Our Ref: A/162/18/HH
Your Ref:

Town & Country Planning Act 1990 (as amended)
Town & country Planning (Development Management Procedure) (England) Order 2015
Application for Planning Permission for Works or Extension to a Dwelling

Development Garden outbuilding.
Location 10 Ashurst Way East Preston

Location

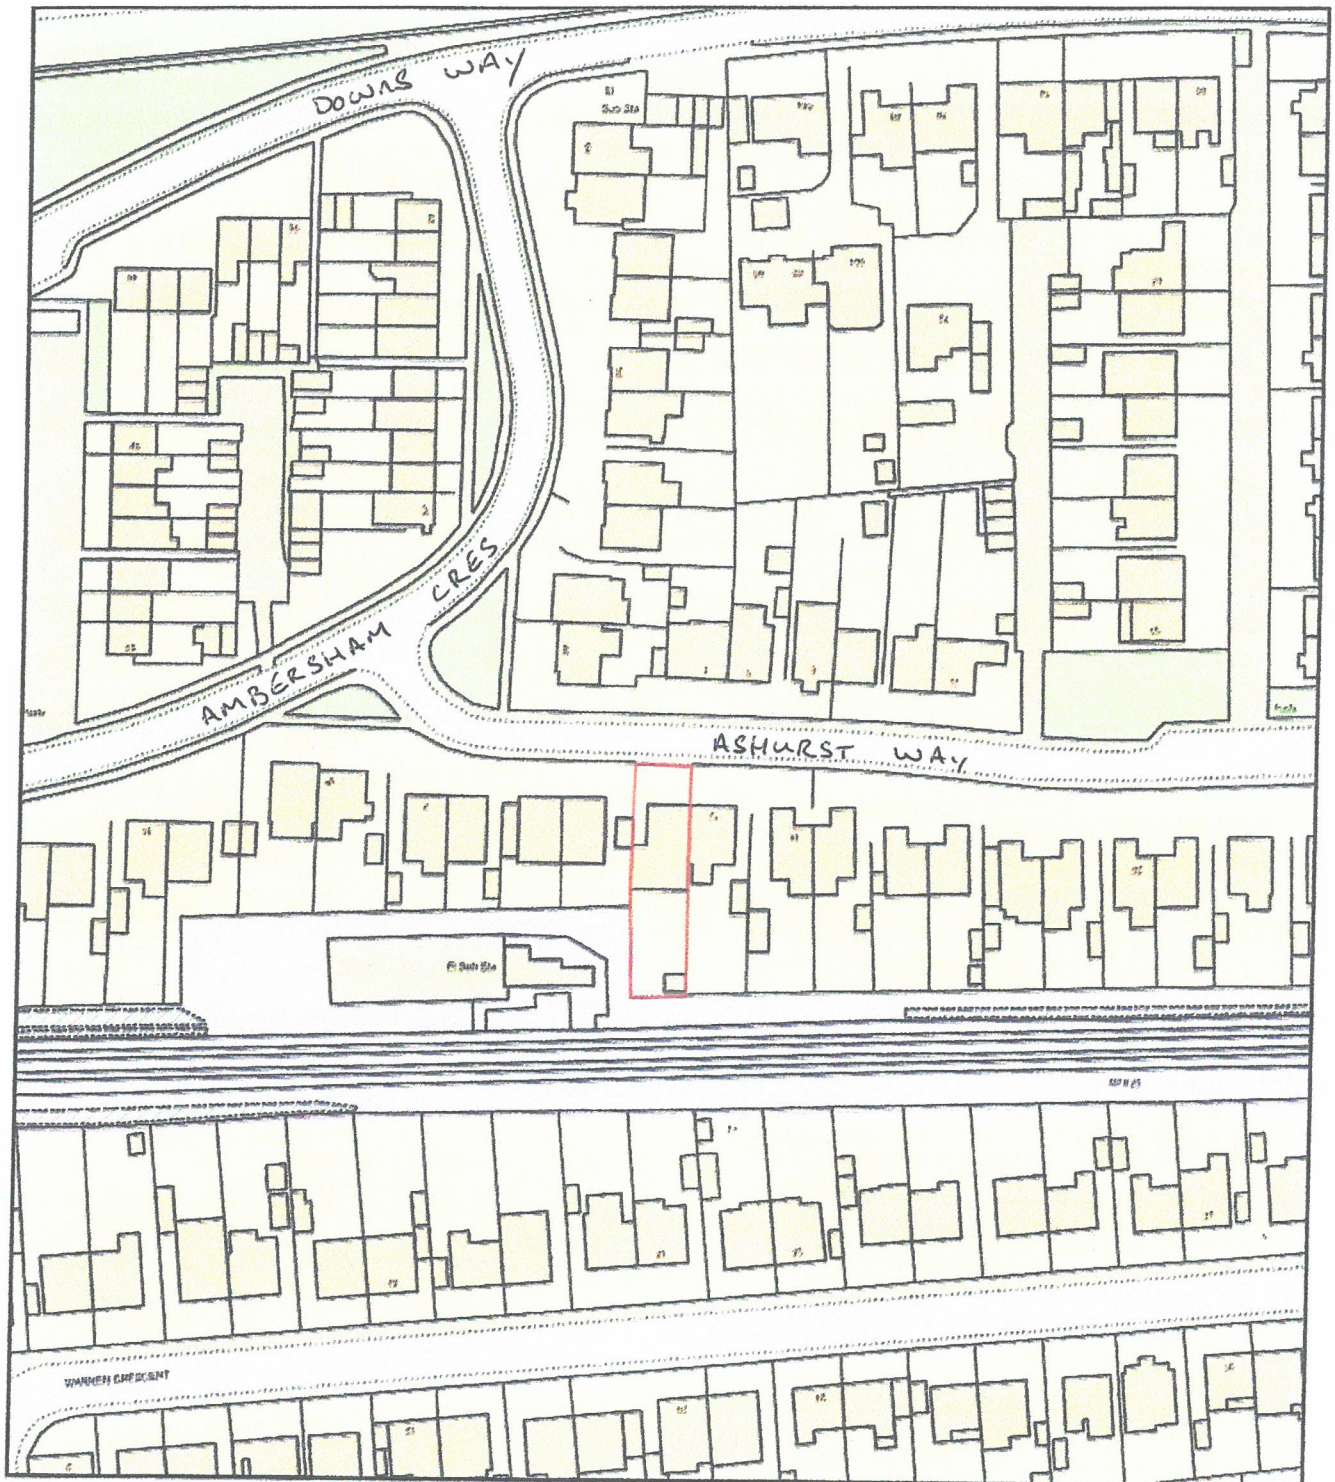
Please submit 1 electronic or 3 paper copies of a location plan at a scale of 1:1250 or 1:2500 for rural areas showing the site area edged in red and 2 named roads. Further details of what must be included on the plan can be found in the National Validation Requirements.

REAR ELEVATION

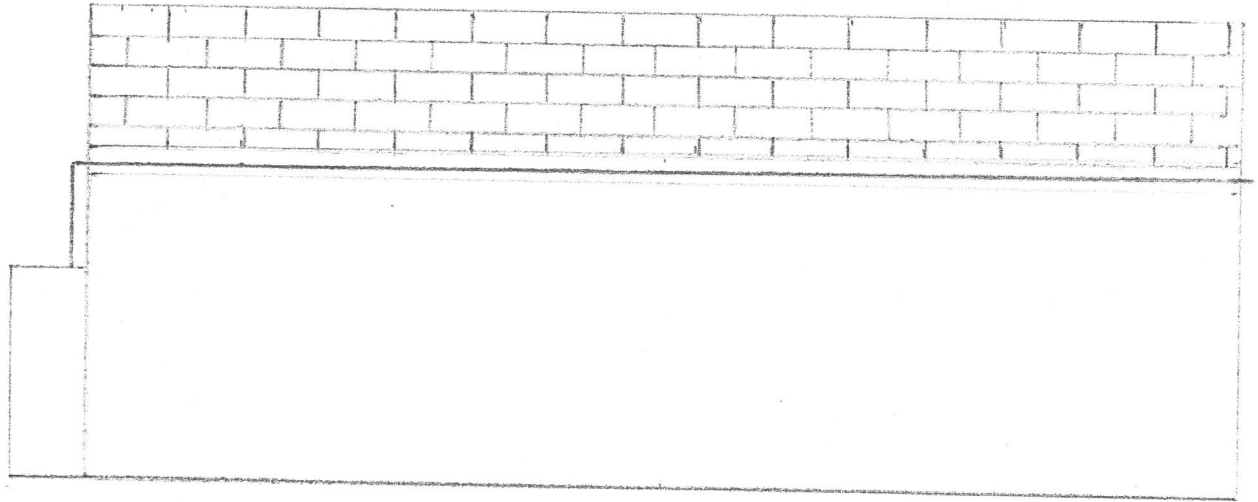
Please submit 1 electronic or 3 paper copies of clearly labelled elevations at a scale of 1:50 or 1:100. All elevations are required,
